# ACOUSTIC LOGIC CONSULTANCY

Reference: 2006520/1408A/R0/VF

## PROJECT STAR – PIRRAMA ROAD FAÇADE ALTERNATIVE DESIGN PROPOSAL – SECTION 75W SUBMISSION

Facade Section  
1:100

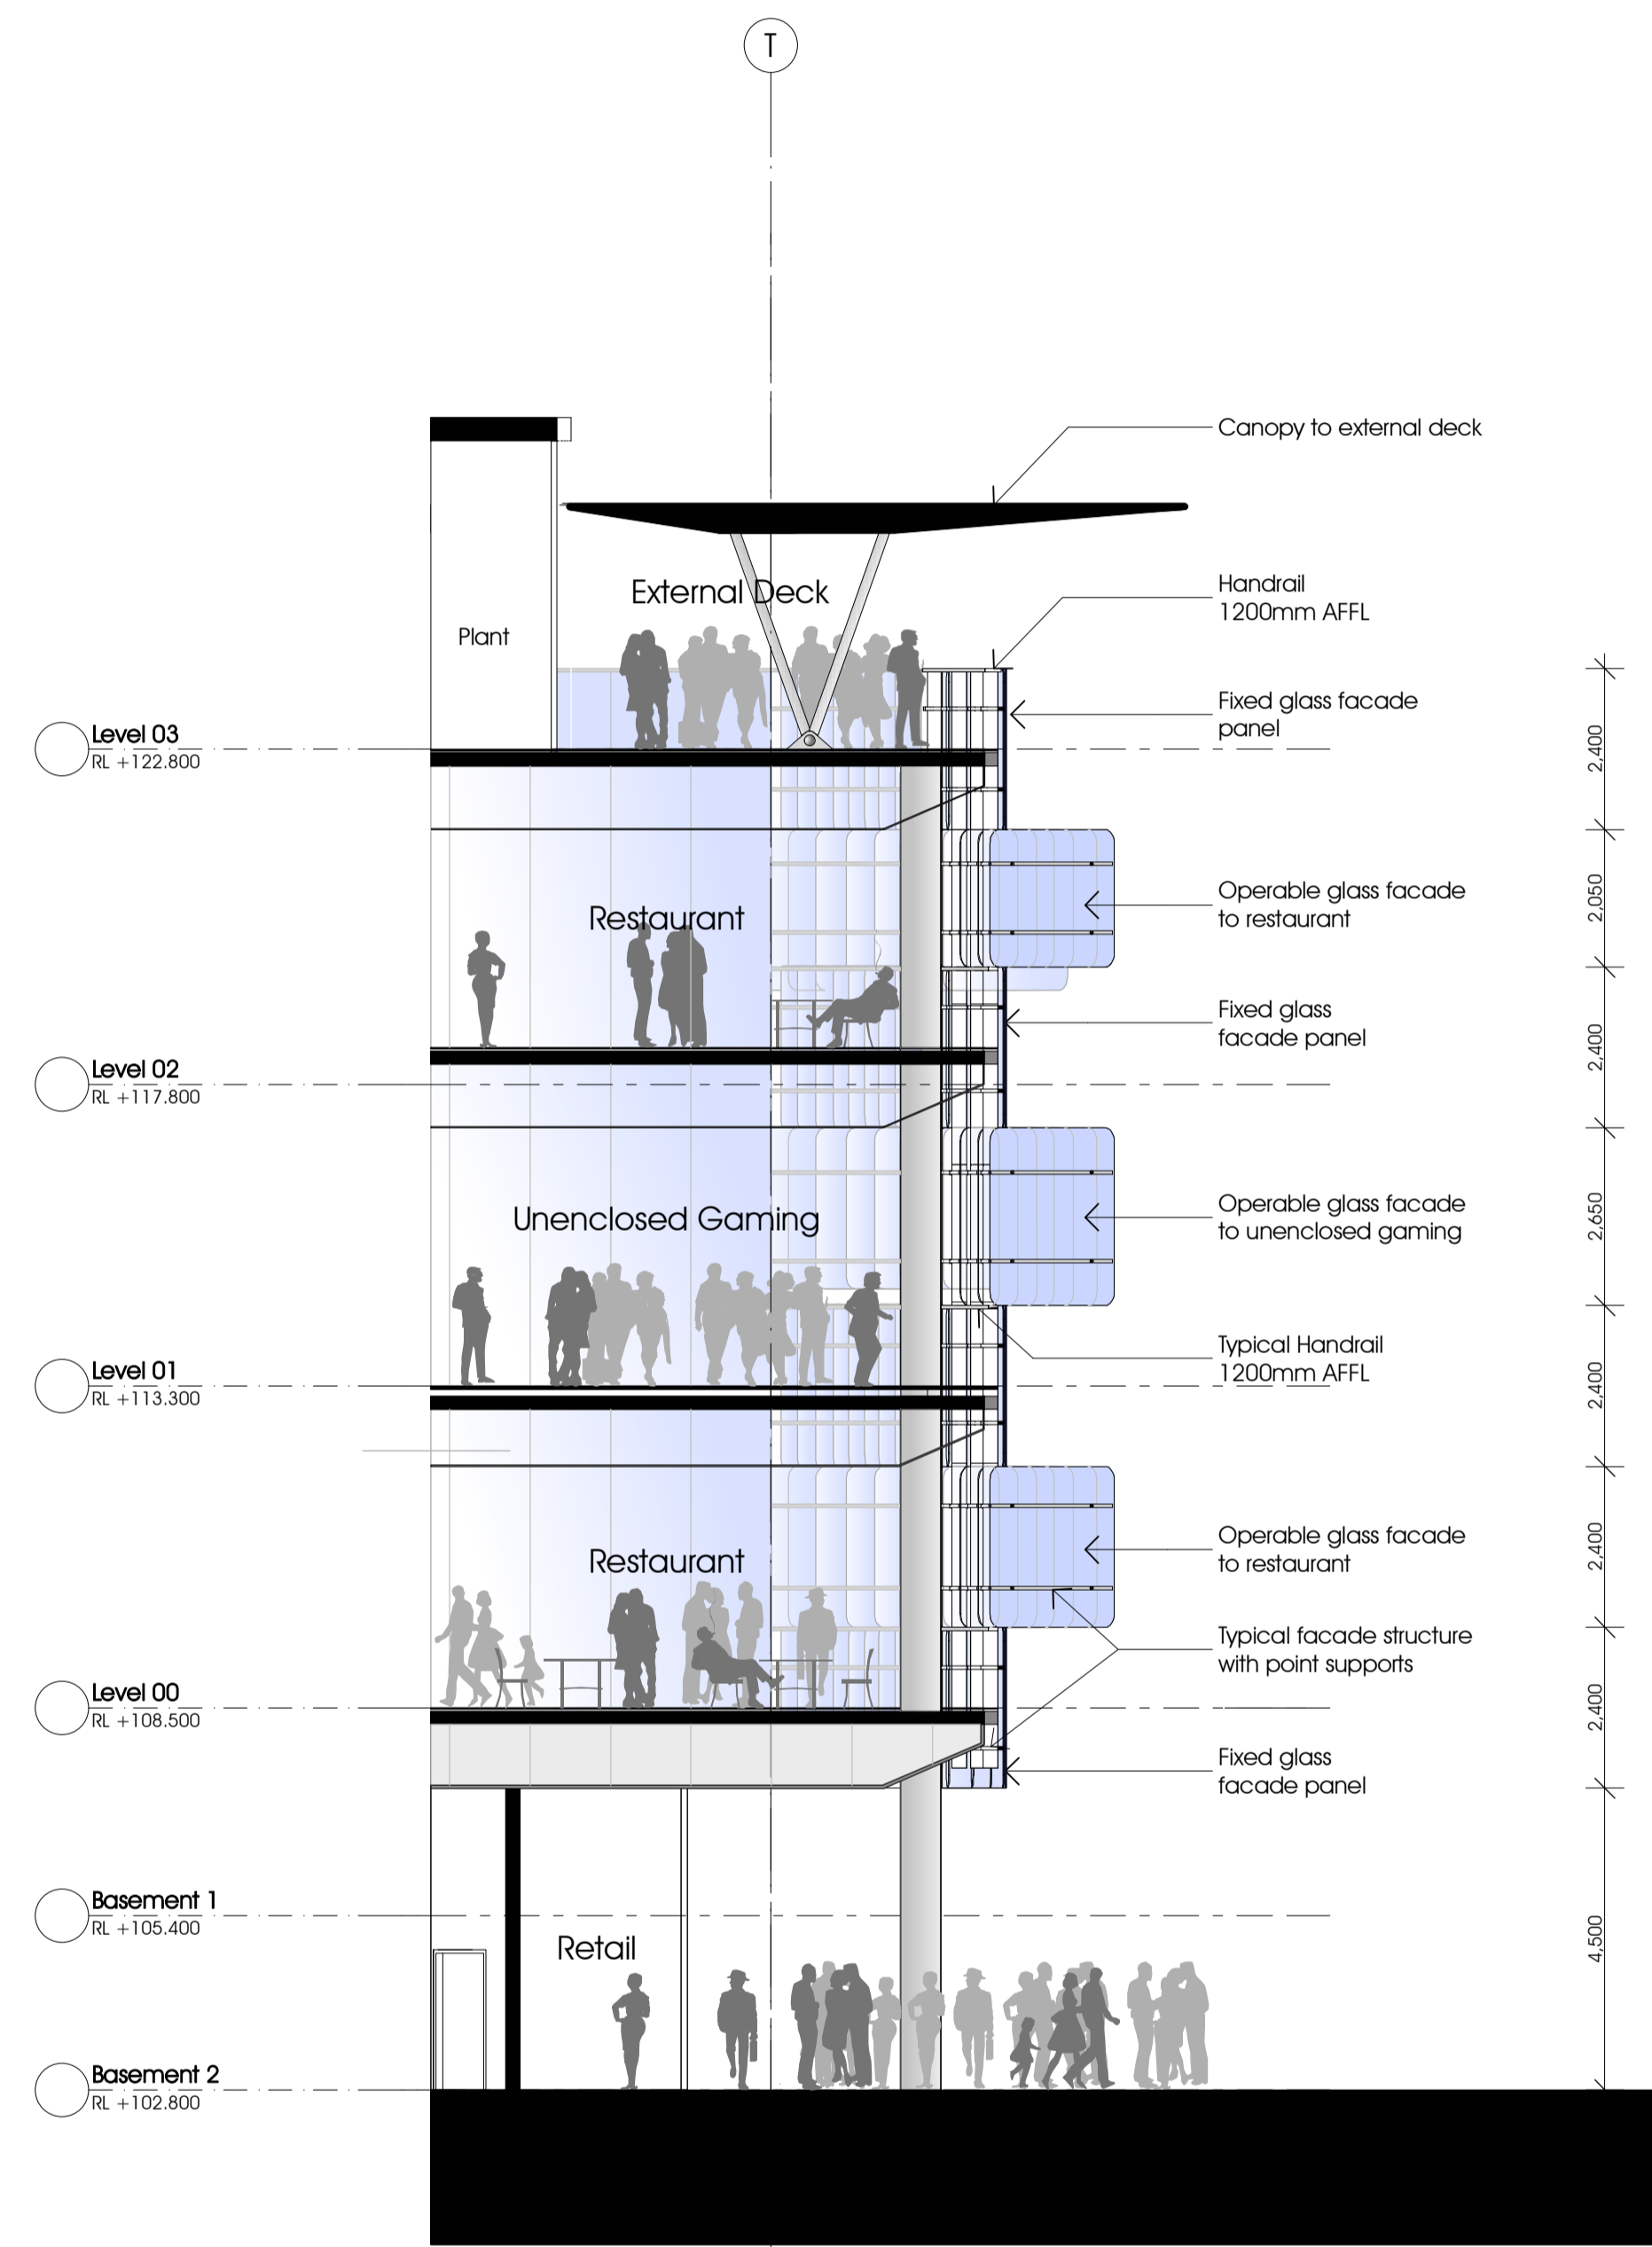
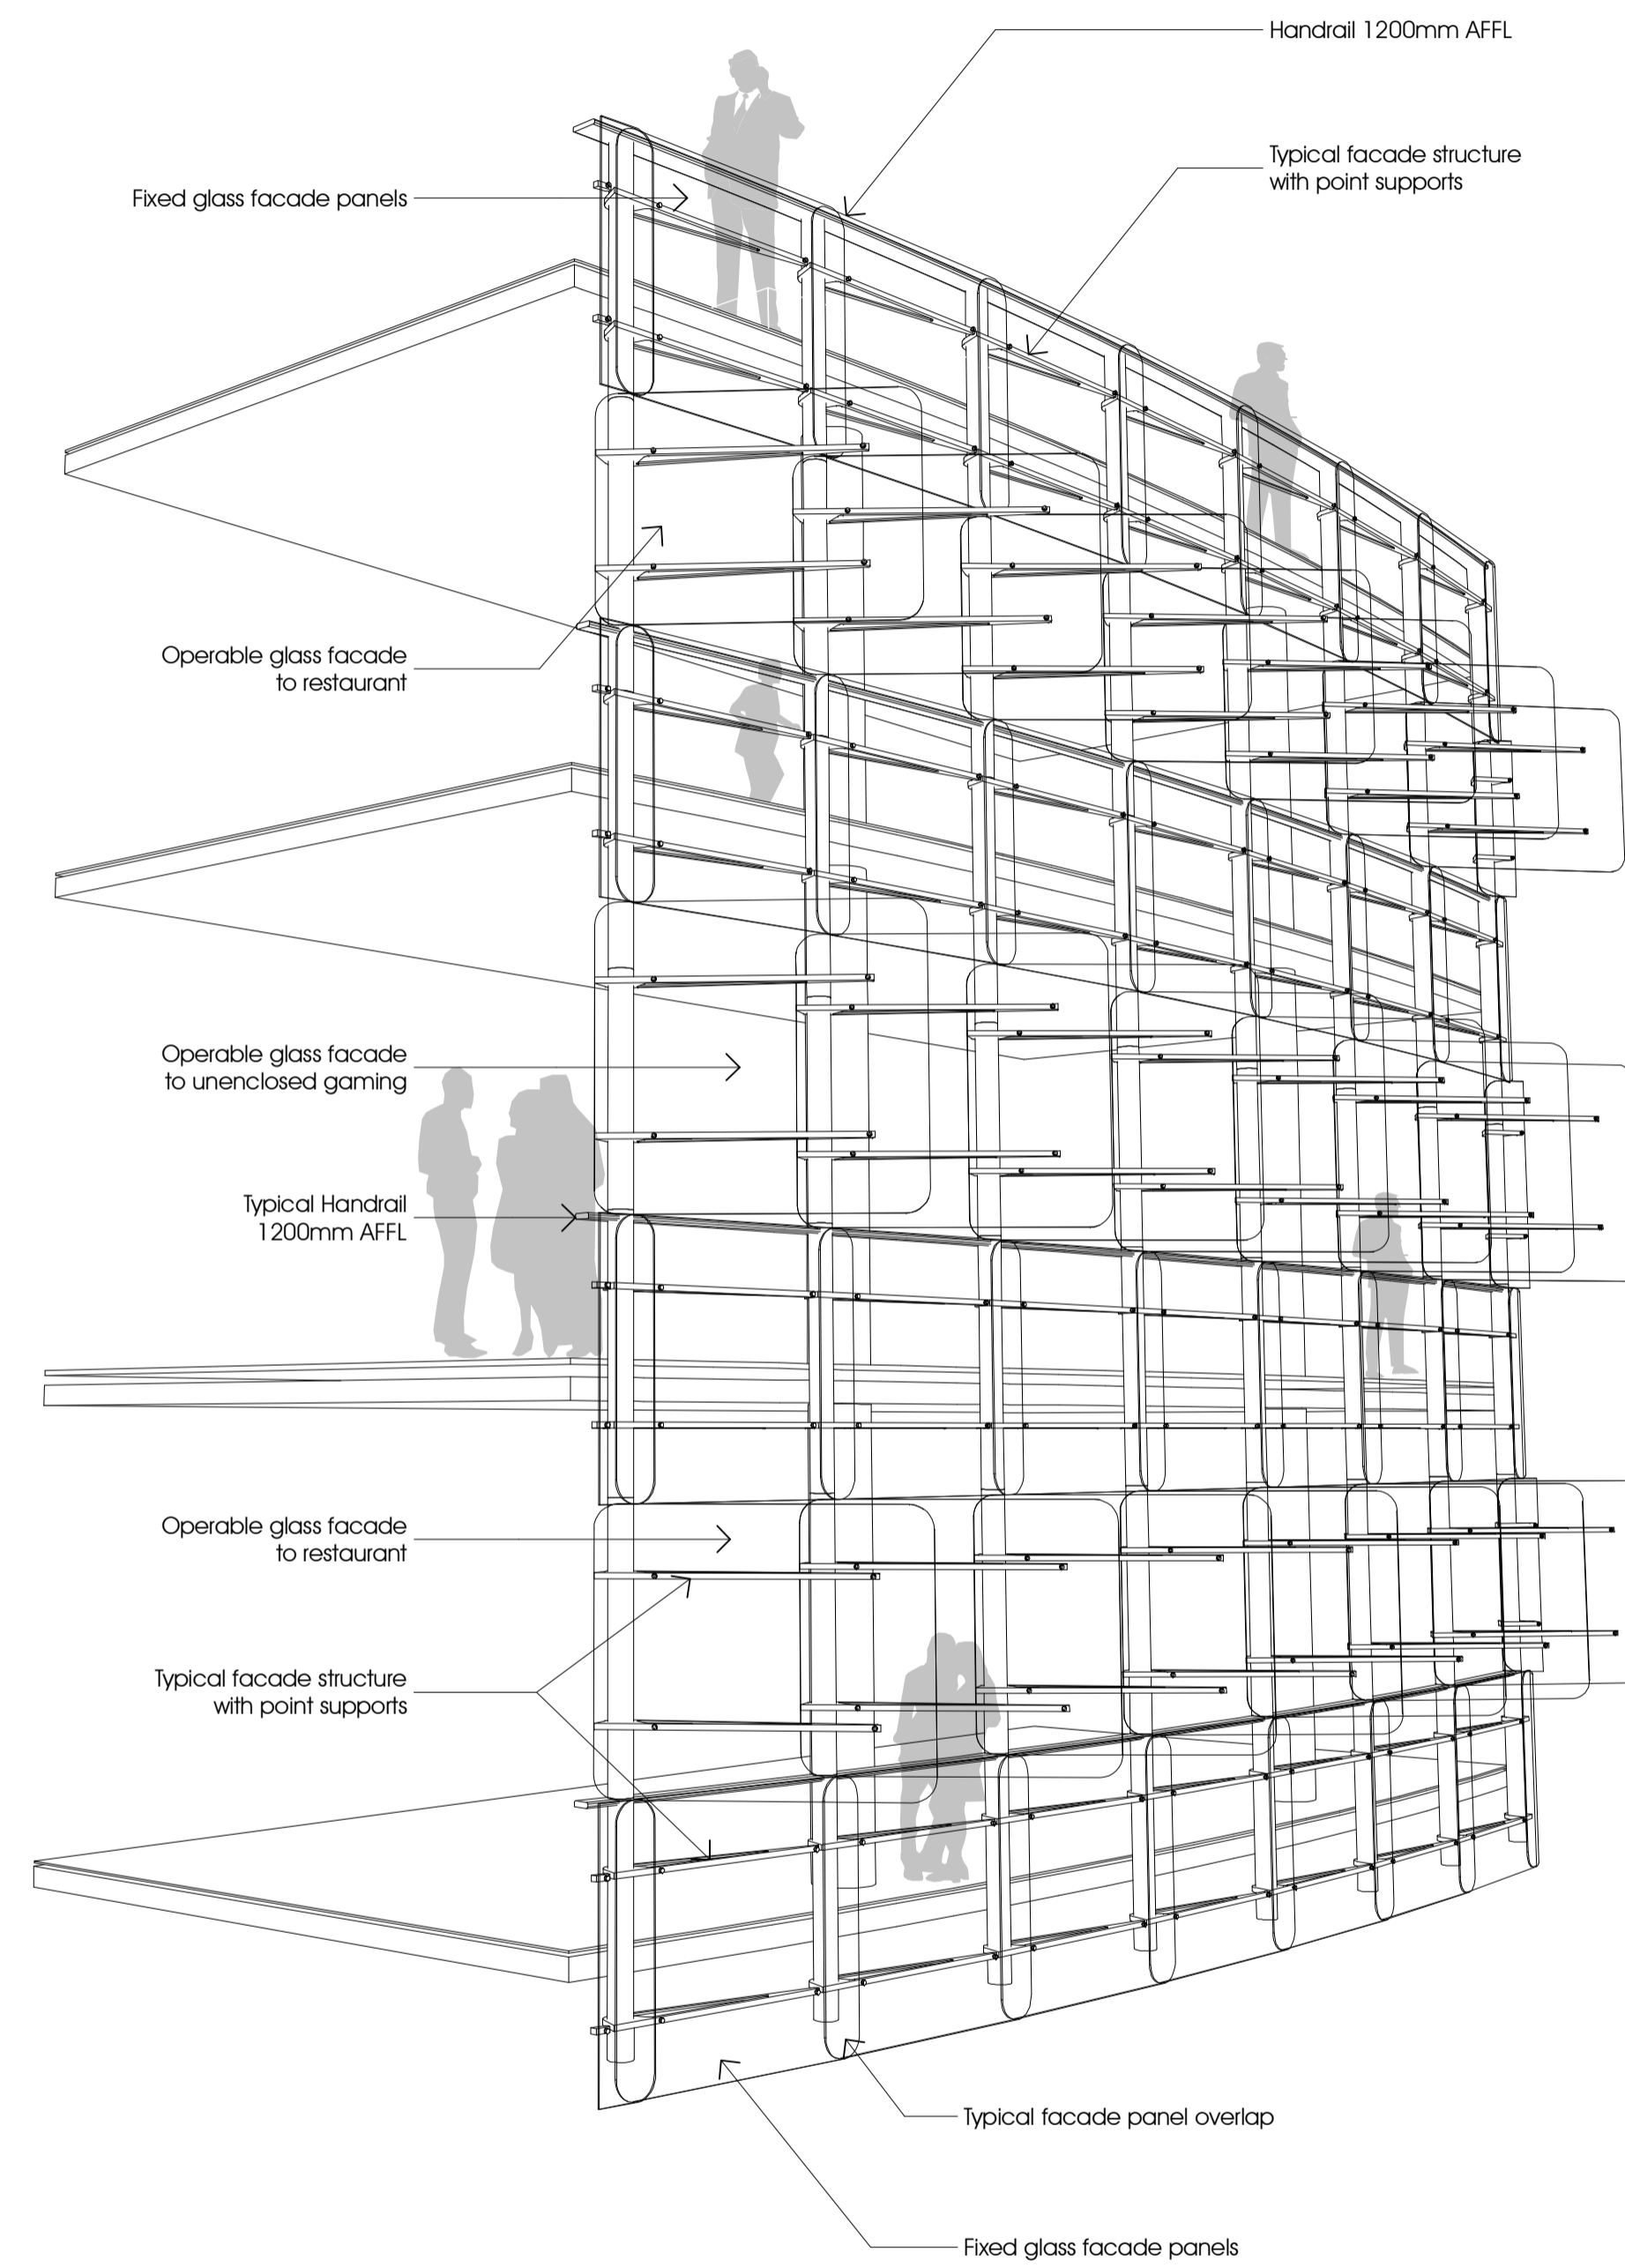
The assessment indicates the proposed façade design proposal would not increase noise emissions to the most impacted receivers provided the following recommendations regarding the roof terrace are adopted:

*The underside of the roof canopy should be highly acoustically absorptive with a minimum NRC of 0.85 and the intended uses of the roof deck would need to be managed in compliance with the limits/controls stipulated in the Noise Management Plan.*
